HOUSE OF COMMONS
LONDON SW1A 0AA

9th January 2024

Dear Mr Jackson,

### ES FIGURE 14.4 - MAIN HNRFI SITE CONCEPT SURFACE WATER DRAINAGE STRATEGY

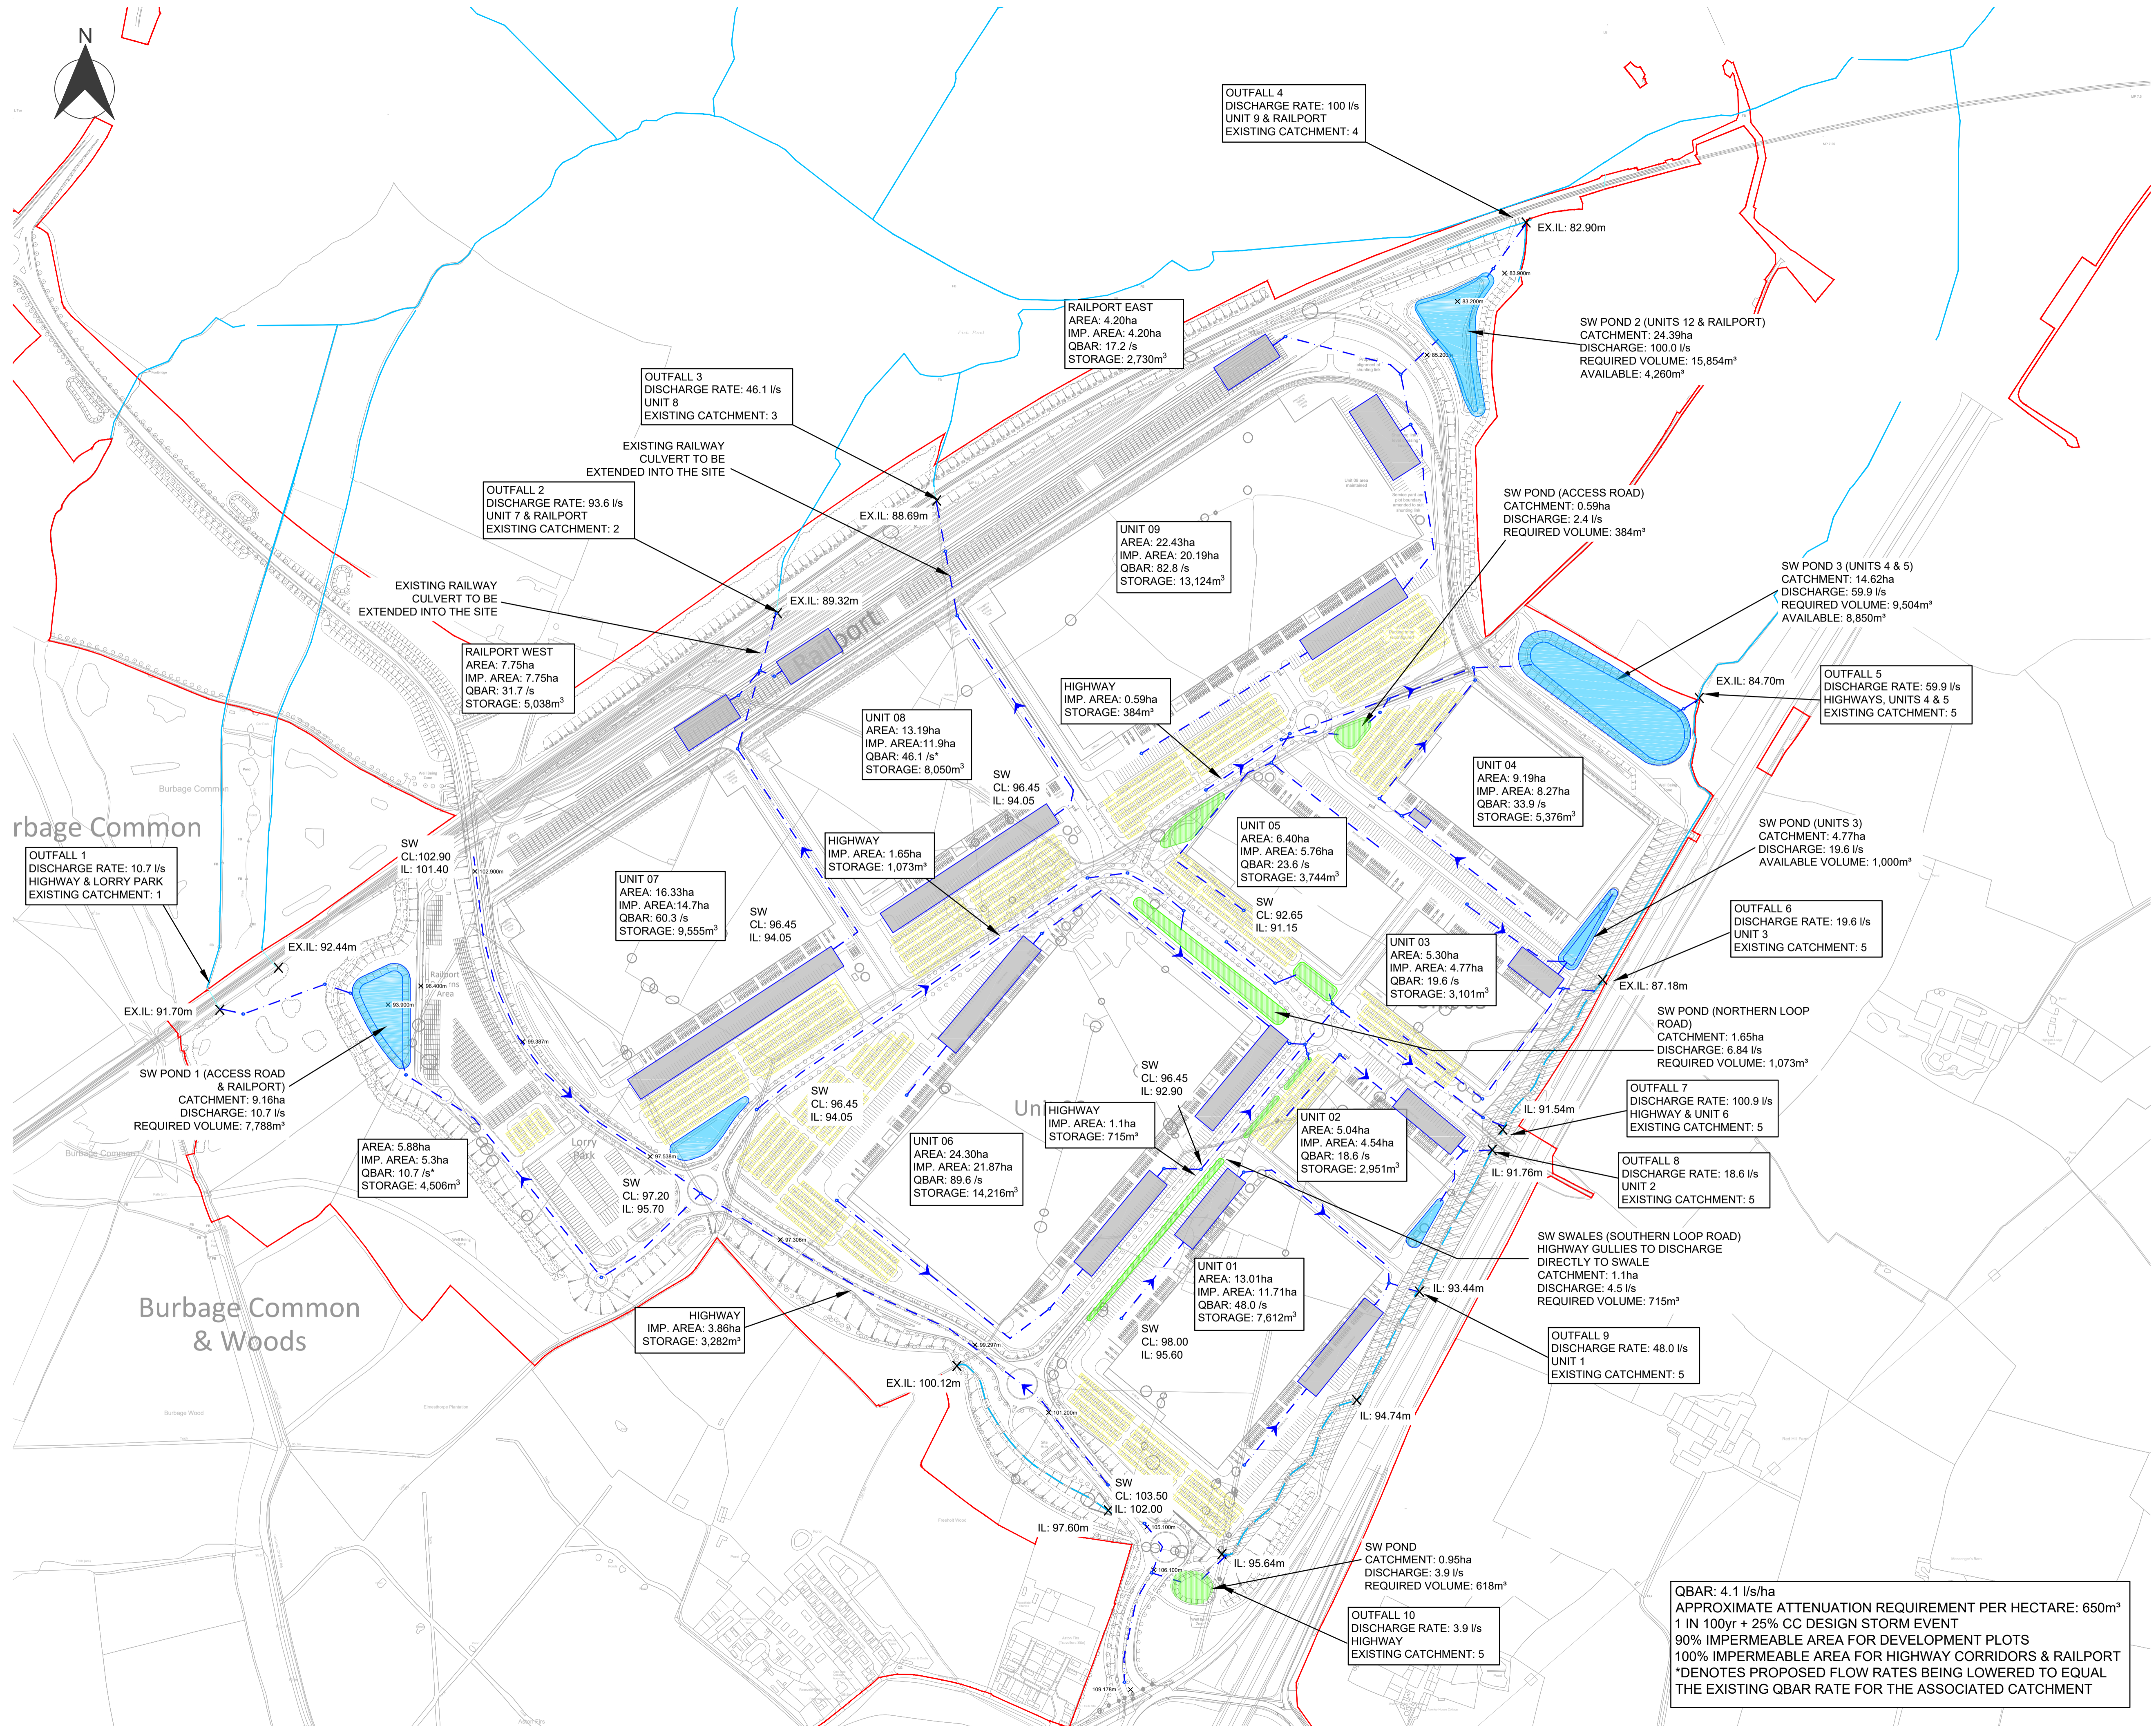
In light of the recent and severe flooding across Leicestershire, can I request that the Examining Authority lend renewed scrutiny to the drainage infrastructure proposed to manage surface water by the Applicant and that this be considered in the context of the most recent flood data in the area to ensure that any proposals will not leave nearby areas exposed to greater flood risk.

**Figure 4: Morning Peak Hour Queuing (worst-case SB Queue)**

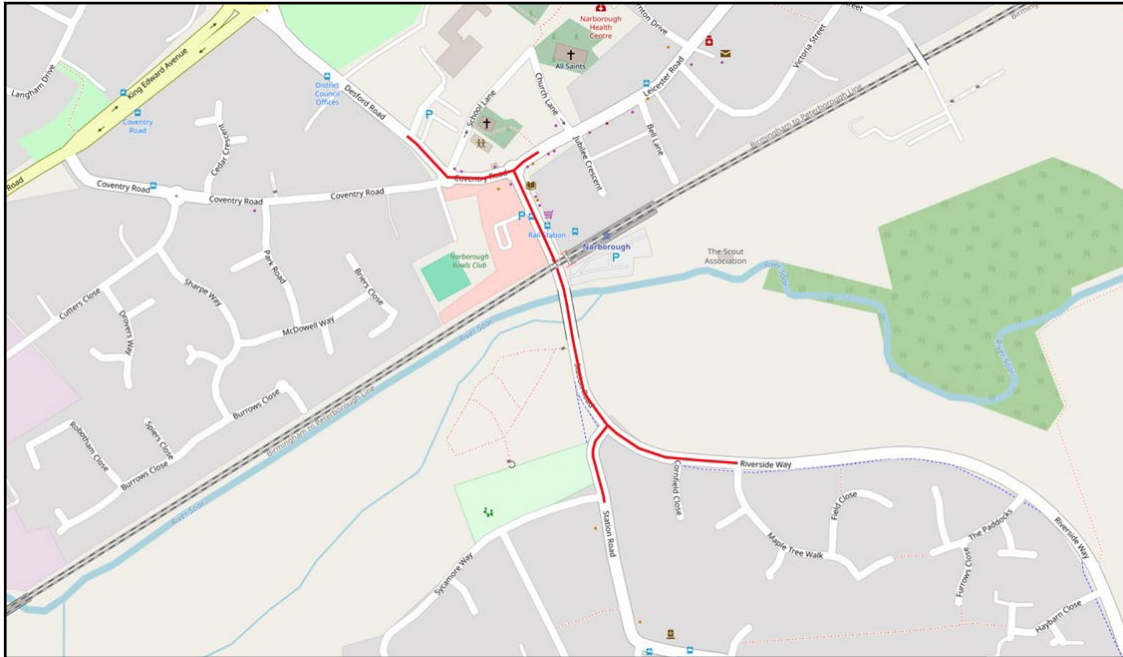
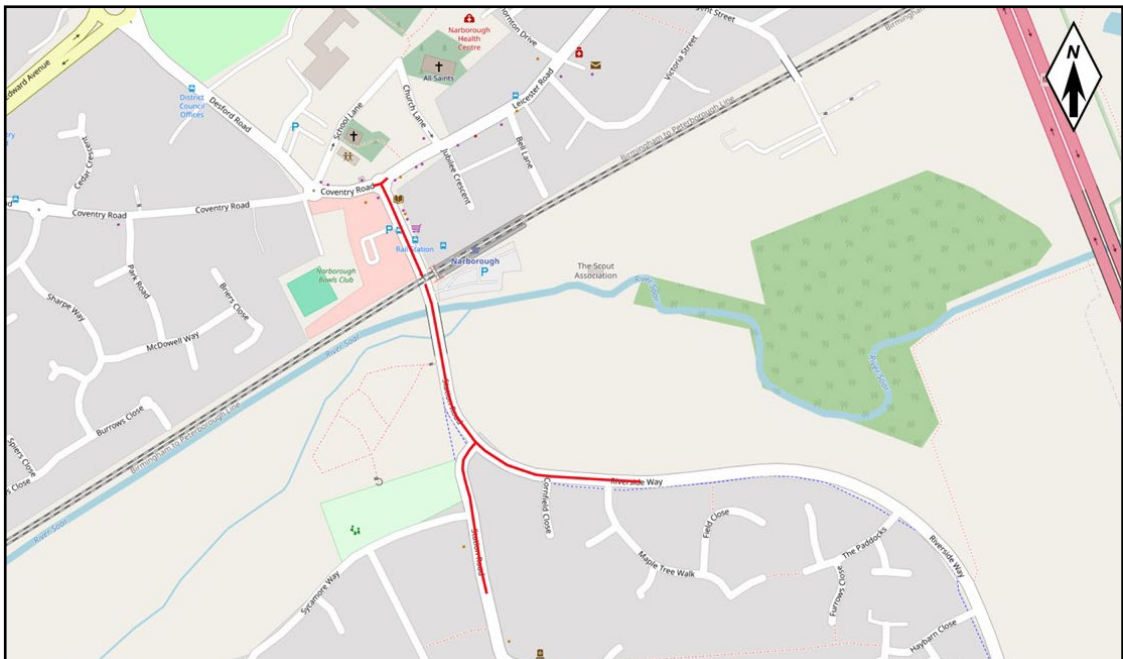
There also remain significant deficiencies in the Applicant's assessment of traffic and barrier downtime at Narborough Level Crossing. What the applicant states is as an "acceptable" barrier down-time does not take in to account the levels of car-traffic congestion on the roads of Narborough and Littlethorpe which is already excessive at peak times.

The lack of "worst case scenario" modelling adds to concerns that incidents and delays on the South Leicestershire rail line are not being factored into the application. I am concerned about the increased the probability of rail incidents and delays with HNRFI. As John Harrison, and the wonderful volunteers at Friends of Narborough Station have pointed out, the South Leicestershire Line is not a main line.

No adequate mitigations have been proposed to address this, and further delays are serious matter for road users in Narborough and Littlethorpe and also for parents on the school run with young children and pushchairs, and for people with disabilities.
